**A30 Chiverton to Carland Cross  
TR010026**

**8.25 COMMENTS ON INTERESTED  
PARTY SUBMISSIONS AT DEADLINE 5**

July 2019

A30 Carland to Chiverton 12 Hour Traffic Flows (AM Peak Period) - October 2014 / March 2015

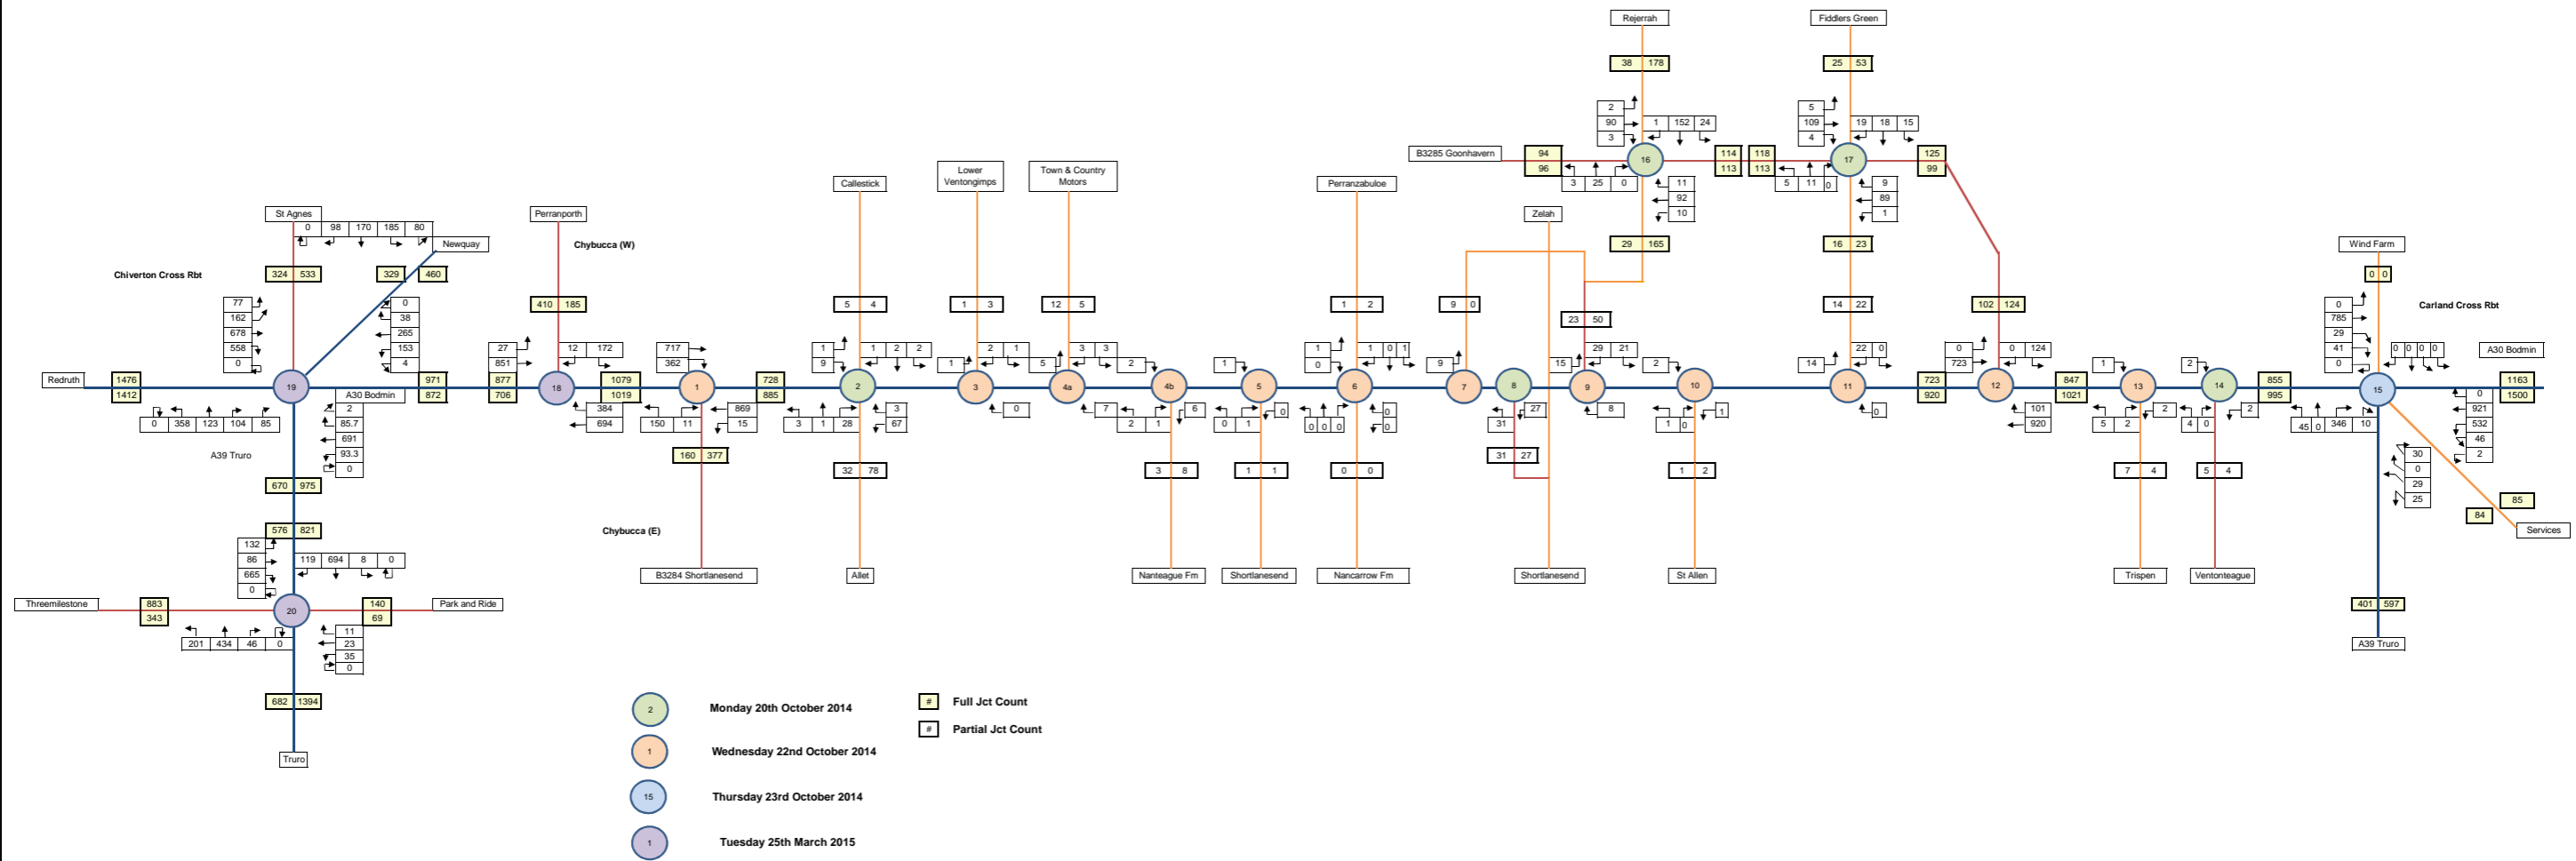
- 2.3.20 In response to the point raised in Paragraph 4.3 of the CCL Technical Note, the right turning traffic at Chybucca (W) from the A30 westbound to the B3284 "Perranporth" northwest bound the figure quoted should be 41 movements (as shown in the updated traffic flow diagram in Appendix A of this document) instead of the 384 movements quoted in Annex A of the PCF Stage 3 Traffic Data Collection Report [REP5-030].

- 2.3.22 The updated observed traffic movement diagram for the AM peak (as shown in Appendix A of this document) addresses the issues raised in Paragraphs 4.3 – 4.7 of the CCL Technical Note.

- 2.3.15 In compiling the response to Section 4 of the CCL Technical Note, it has been noticed there was an error in the data presented in Annex A of the PCF Stage 3 Traffic Data Collection Report [REP5-030] submitted to Highways England by WSP in August 2017. Revised versions of the diagrams included in Annex A of the PCF Stage 3 Traffic Data Collection Report [REP5-030] have been included as Appendix A of this response.

- 2.3.21 The 41 movements compare to 39 movements observed as stated in the PCF Stage 3 Local Model Validation Report [REP5-028]. The slight difference between the observed figure in the LMVR and the revised traffic flow diagram in Appendix A is due to factoring to allow conversion of the flows to passenger car units (pcus). The modelled turning movement for this movement across the junction in the A30 base year traffic model is 96 movements. The difference between the observed and modelled flow is within the threshold (being individual flows within 100 vehicles per hour (veh/hr) of the observed flow) which is required by the WebTAG model validation criteria for this turning movement, demonstrating that the model validates at this location.

A30 Carland to Chiverton 12 Hour Traffic Flows (PM Peak Period) - October 2014 / March 2015

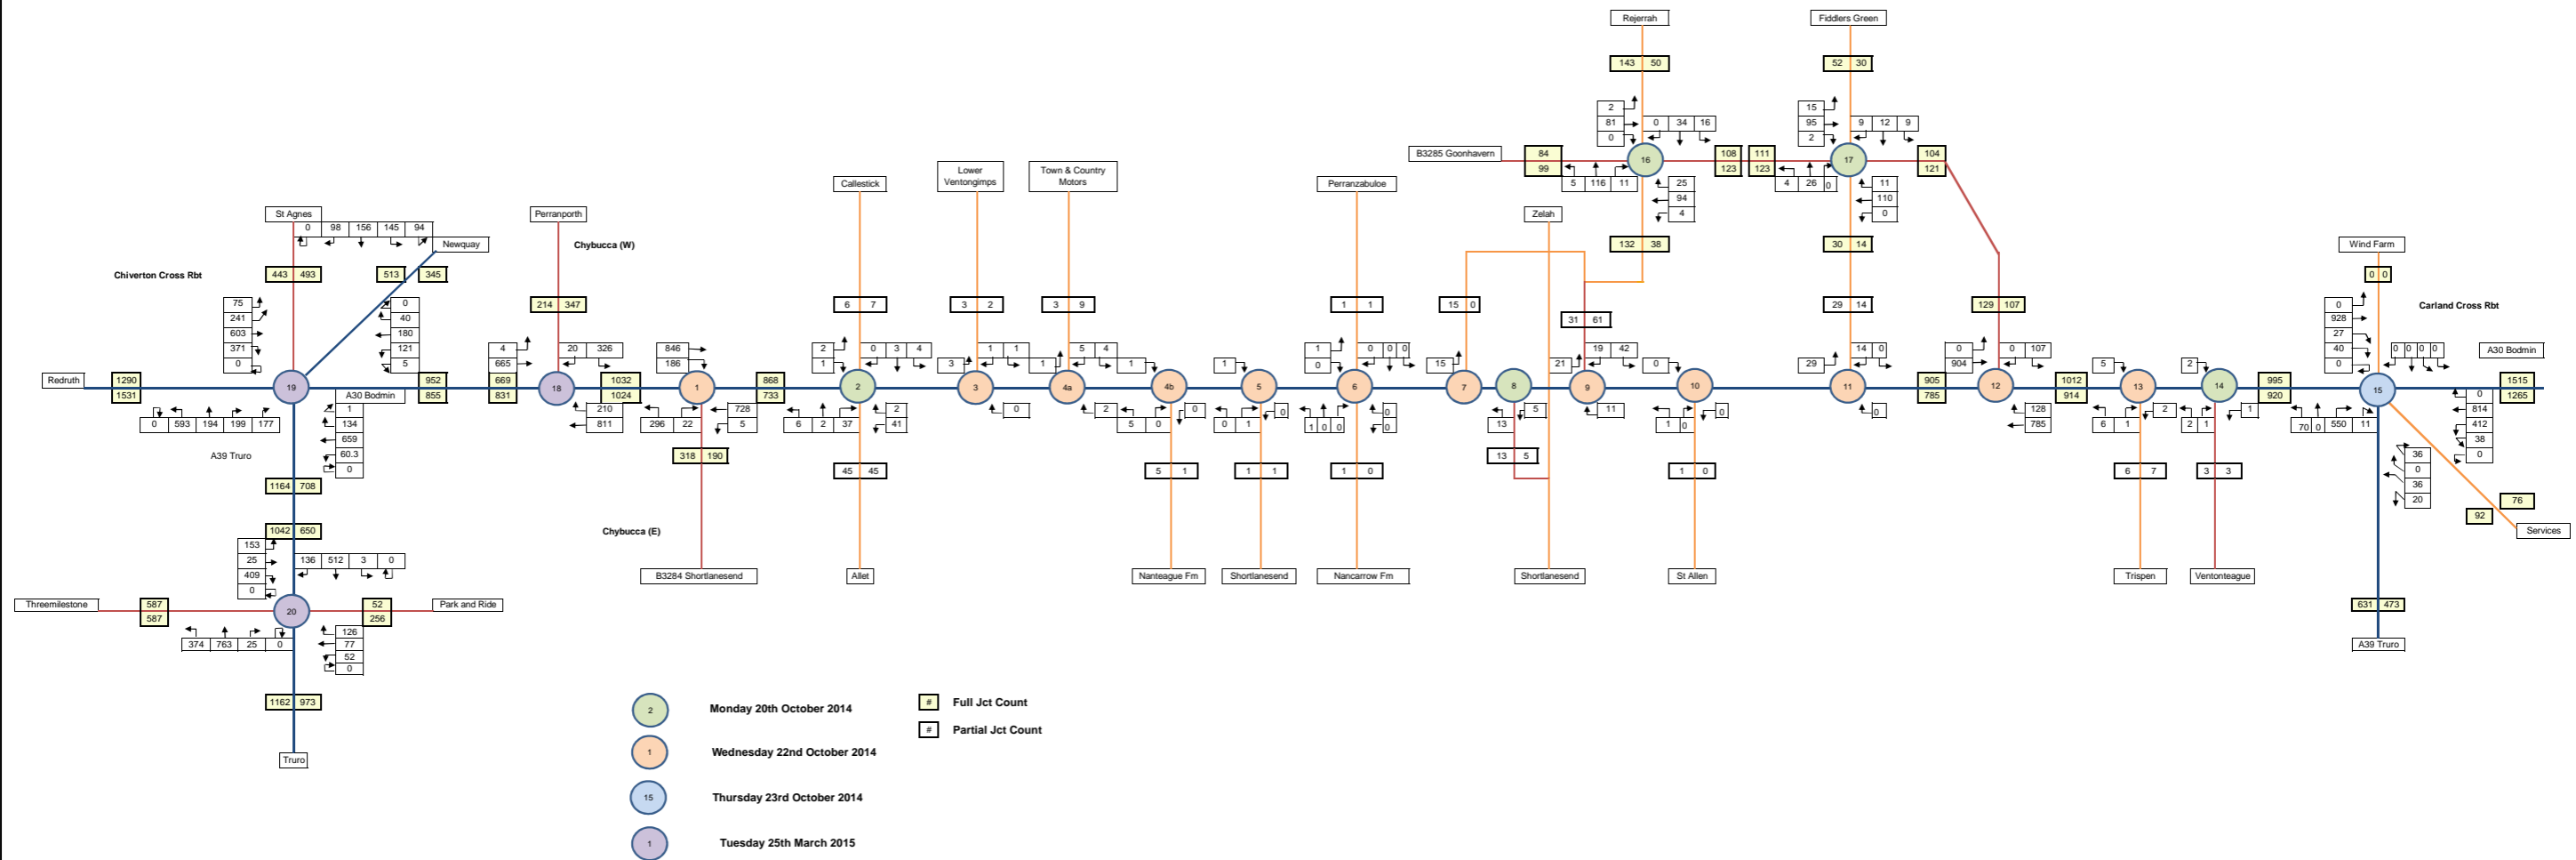
- 2.3.25 In response to paragraph 4.11, reviewing the left turning traffic at Chybucca (W) from the B3284 "Perranporth" southeast bound to the A30 eastbound, the figure quoted should be 54 movements (as shown in the updated traffic flow diagram in Appendix A of this response) compared to the 326 movements quoted in Annex A of the PCF Stage 3 Traffic Data Collection Report [REP5-030]. The 54

- 2.3.26 The updated observed traffic movement diagram for the PM peak (as shown in Appendix A) addresses the issues raised in Paragraphs 4.11 – 4.16 of the CCL Technical Note.

movements compare to 56 movements observed as stated in the PCF Stage 3 Local Model Validation Report [REP5-028]. The slight difference between the observed figure in the PCF Stage 3 Local Model Validation Report [REP5-028] and the revised traffic flow diagram is due to factoring to allow conversion of the flows to passenger car units (pcus). The same modelled turning movement in the A30 base year traffic model is 108 movements which is within the threshold required by the WebTAG model validation criteria for this turning movement, demonstrating that the model validates at this location.
